STATE OF NORTH CAROLINA
DEPARTMENT OF TRANSPORTATION

Addendum No. 1

RE: Contract # C204778
WBS # 2023CPT.05.04.10921.1, etc.
STATE FUNDED

3 SECTIONS OF US-70 AND 5 SECTIONS OF SECONDARY ROADS.

**TYPICAL SECTION NO. 4**

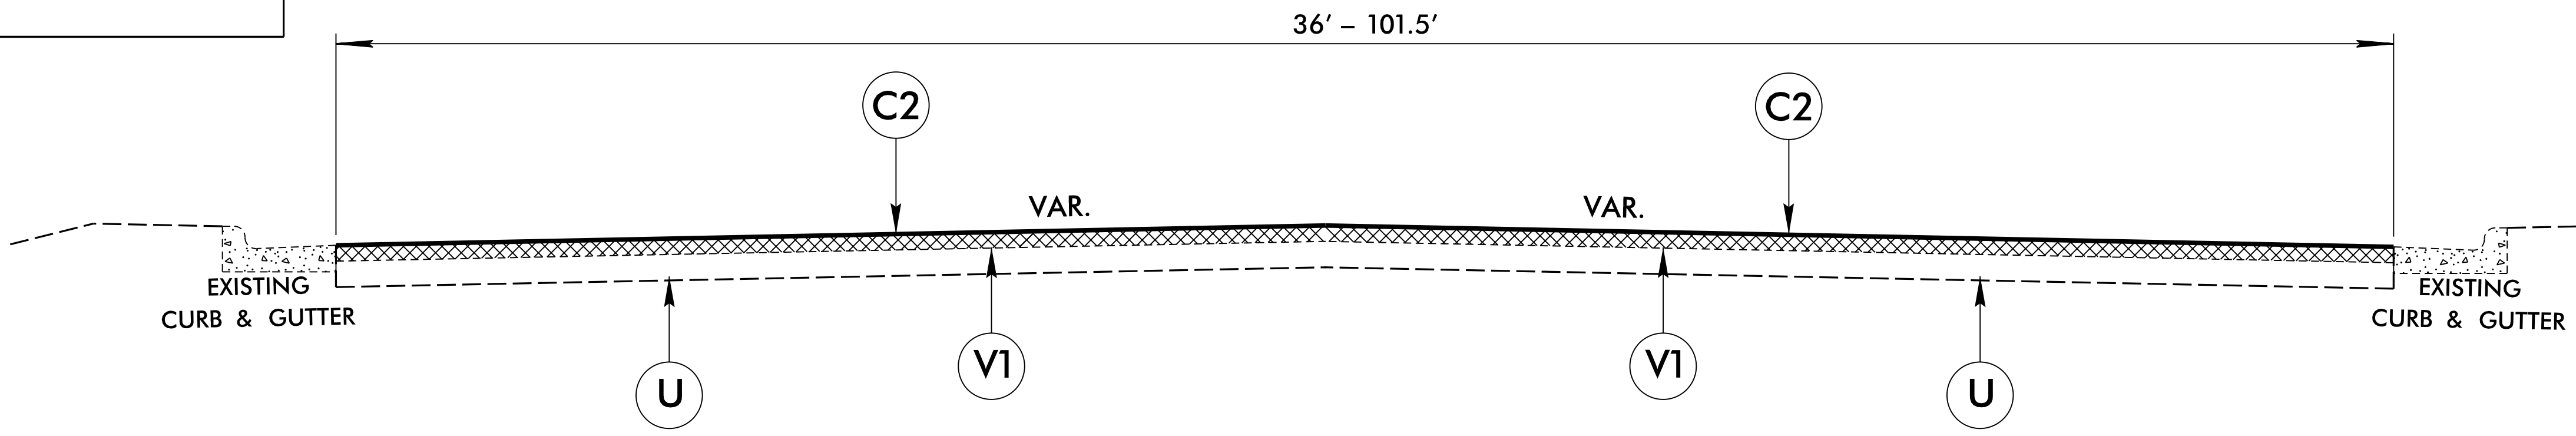
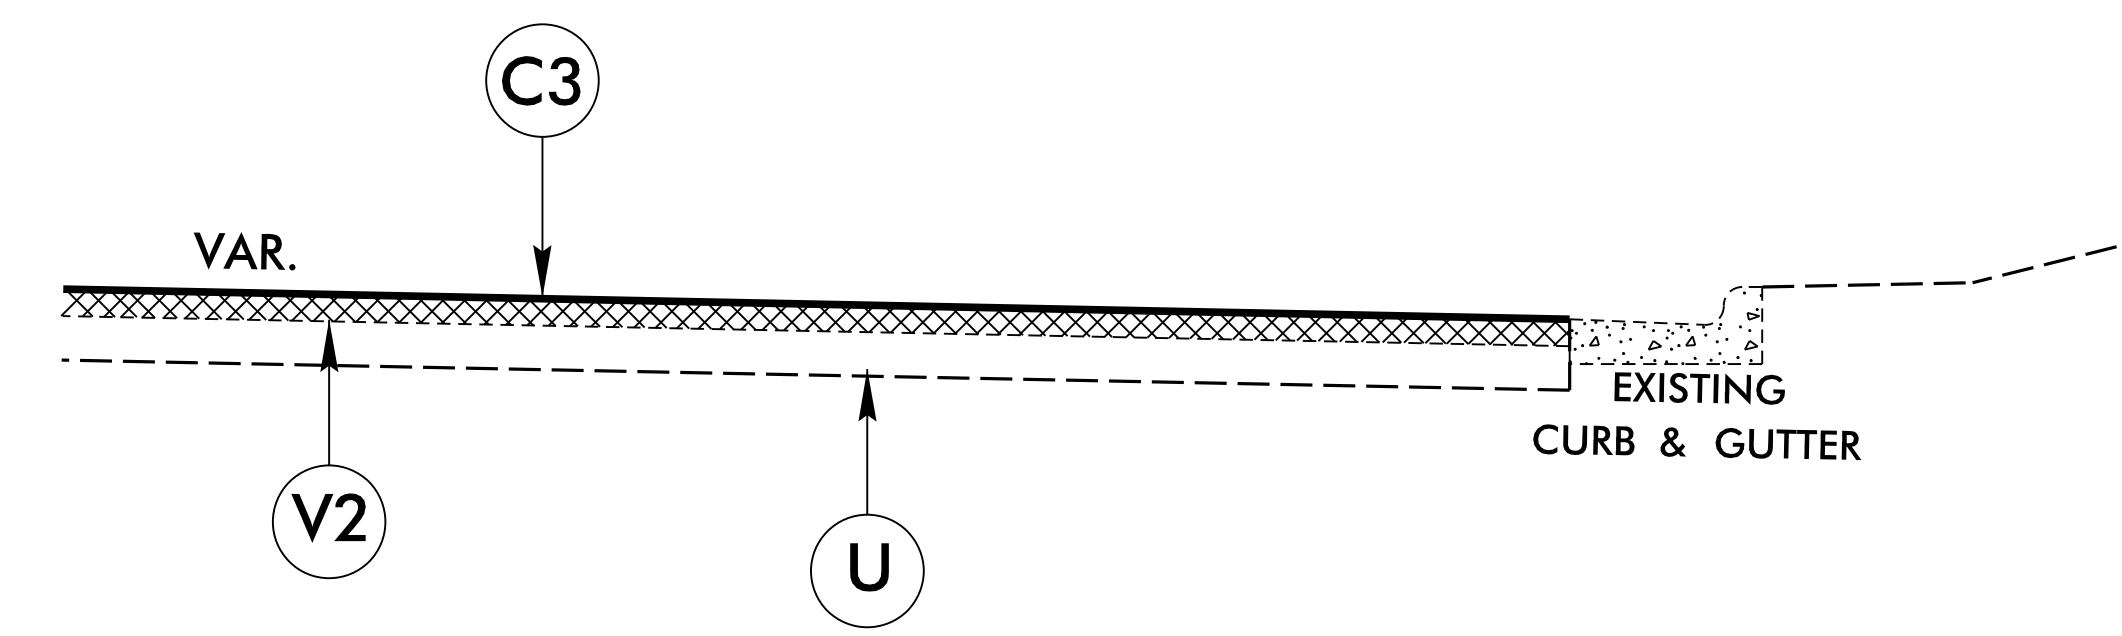
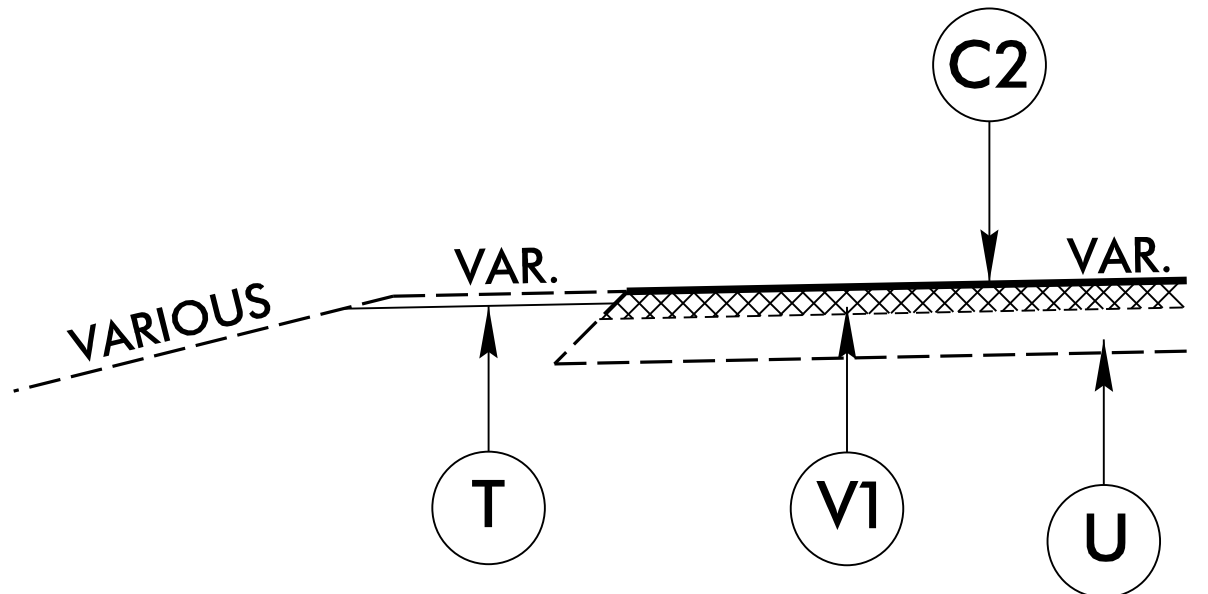
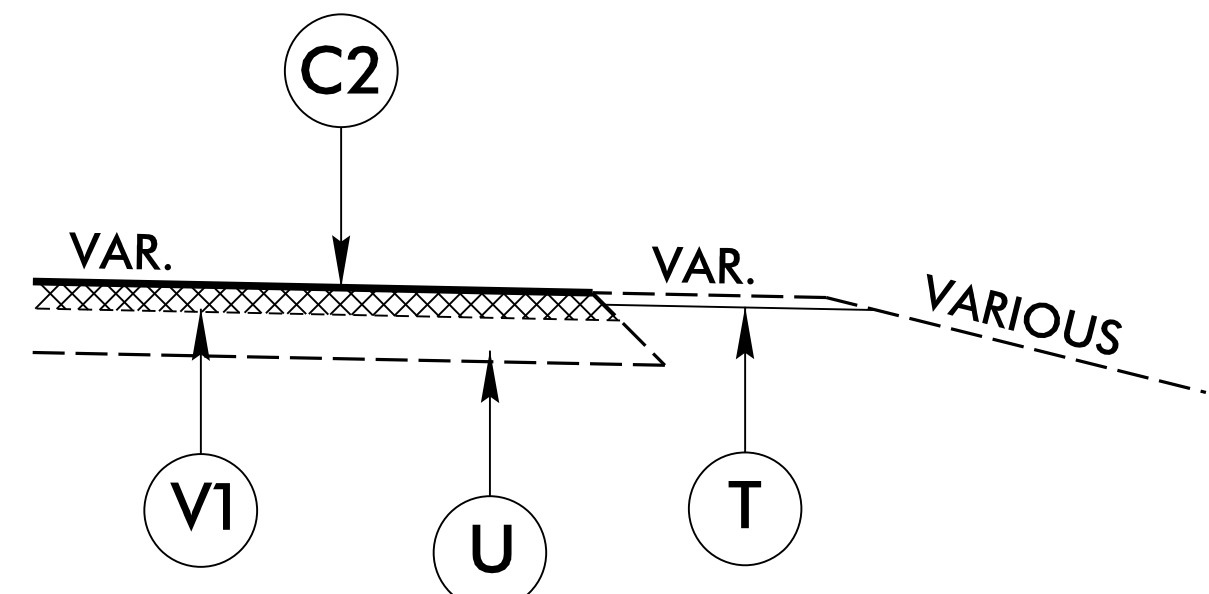
Sheet No.	Revision
18 (Typical Section No. 4)	“V2” in the Pavement Schedule revised.
